From: Anita Gardner
Sent: 21 December 2017 11:27
To: Karen Parsons
Subject: FW: LU/267/17/PL 2 flats Chilgrove House

Anita Gardner | Principal Planner, Directorate of Place, Arun District Council | Location: First Floor, Arun Civic Centre, Maltravers Road, Littlehampton, BN17 5LF

TITLE
PROPOSED LAYOUT
AND ELEVATIONS
-

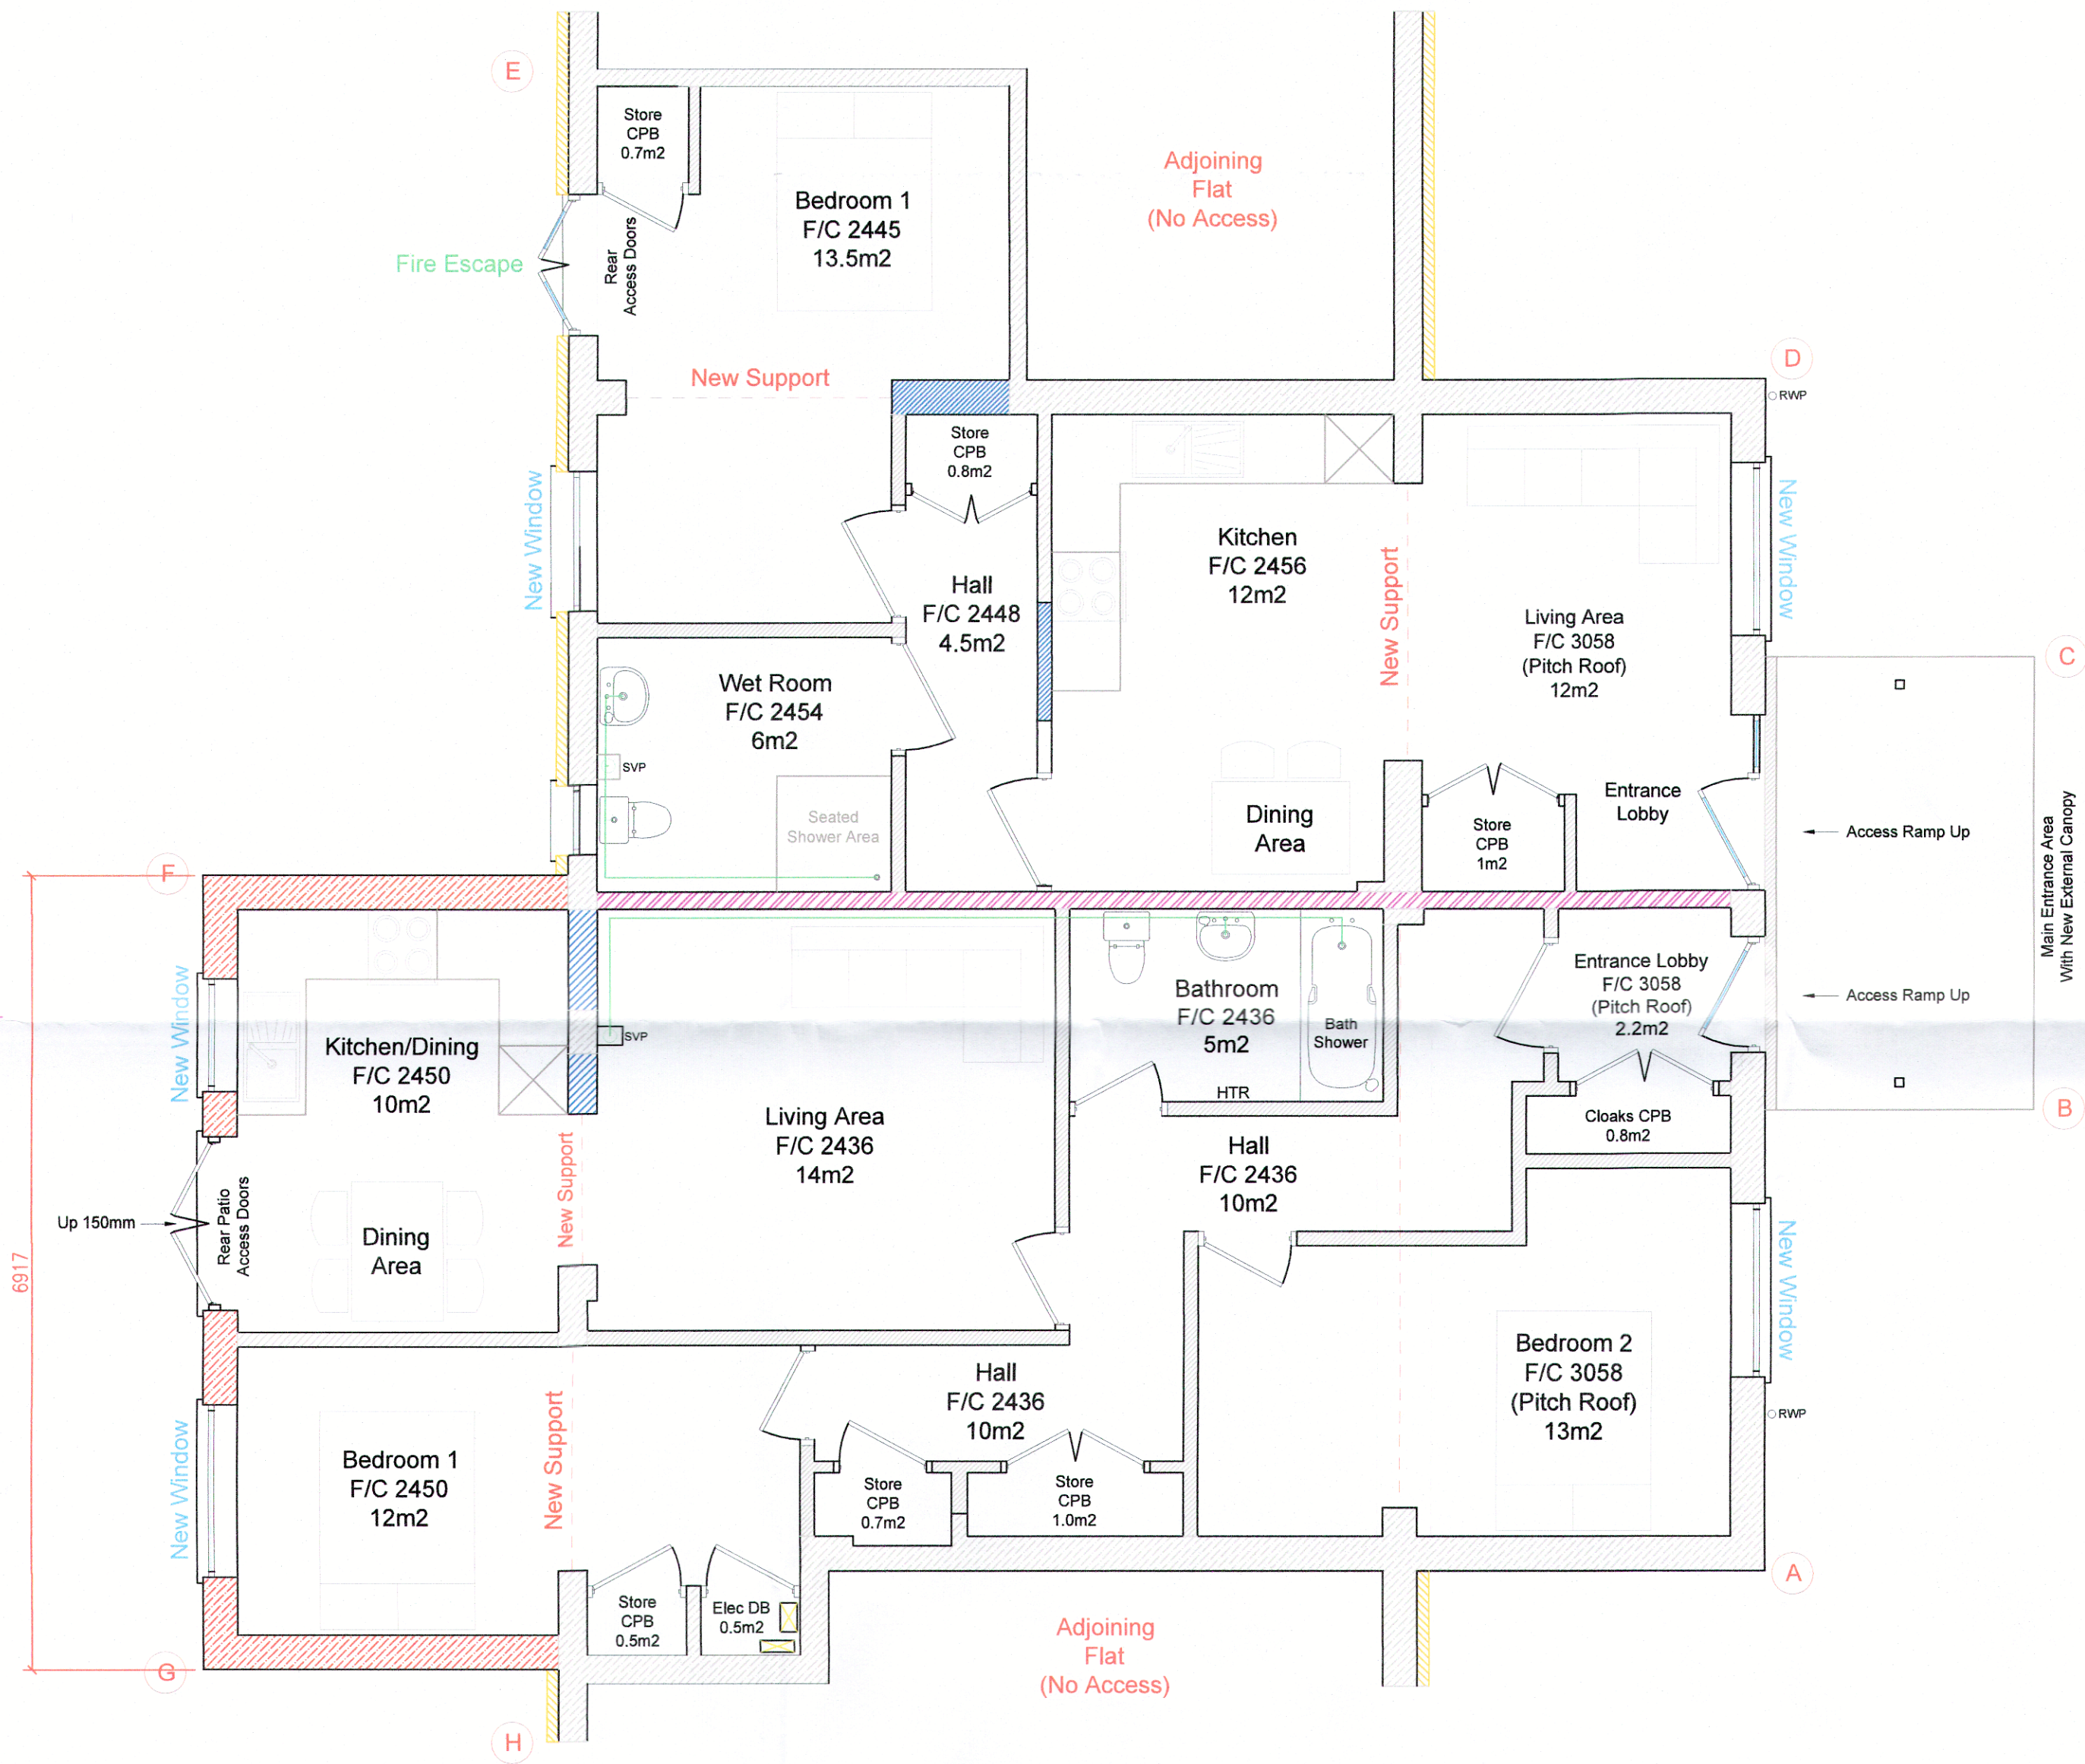
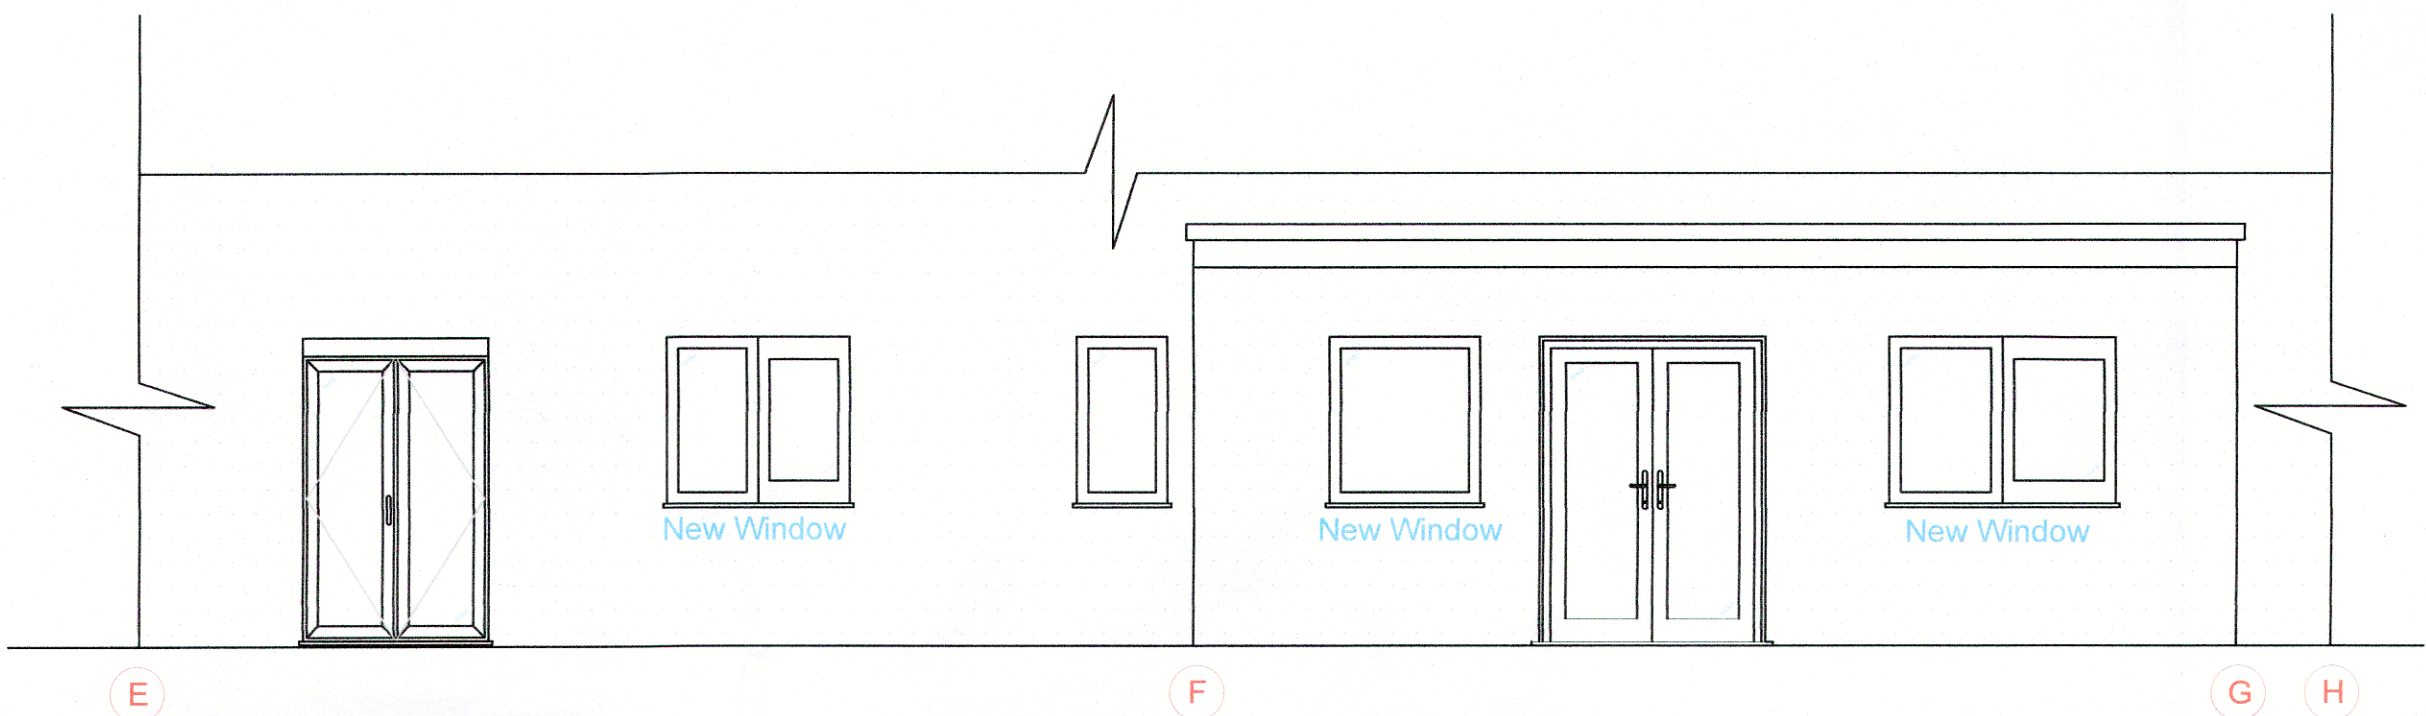
I also note that there are no side elevations of the extensions and these should be included with the additional information.

I need to be able to identify from floor plans and elevation plans the precise location of the rear extension in relation to the rooms both sides. The floor plan extract only shows one of the rooms adjacent to the proposed extension, that to the south, so that I cannot consider the impact of the extension on the residential amenity of both adjoining units including that to the north.

The elevation extract is insufficient to identify the precise position of the extension on the whole elevation. It is not clear where on the rear elevation it would be located. I would like to see it either superimposed on a photo or on an elevation showing the whole of the northern portion of the rear eastern elevation.
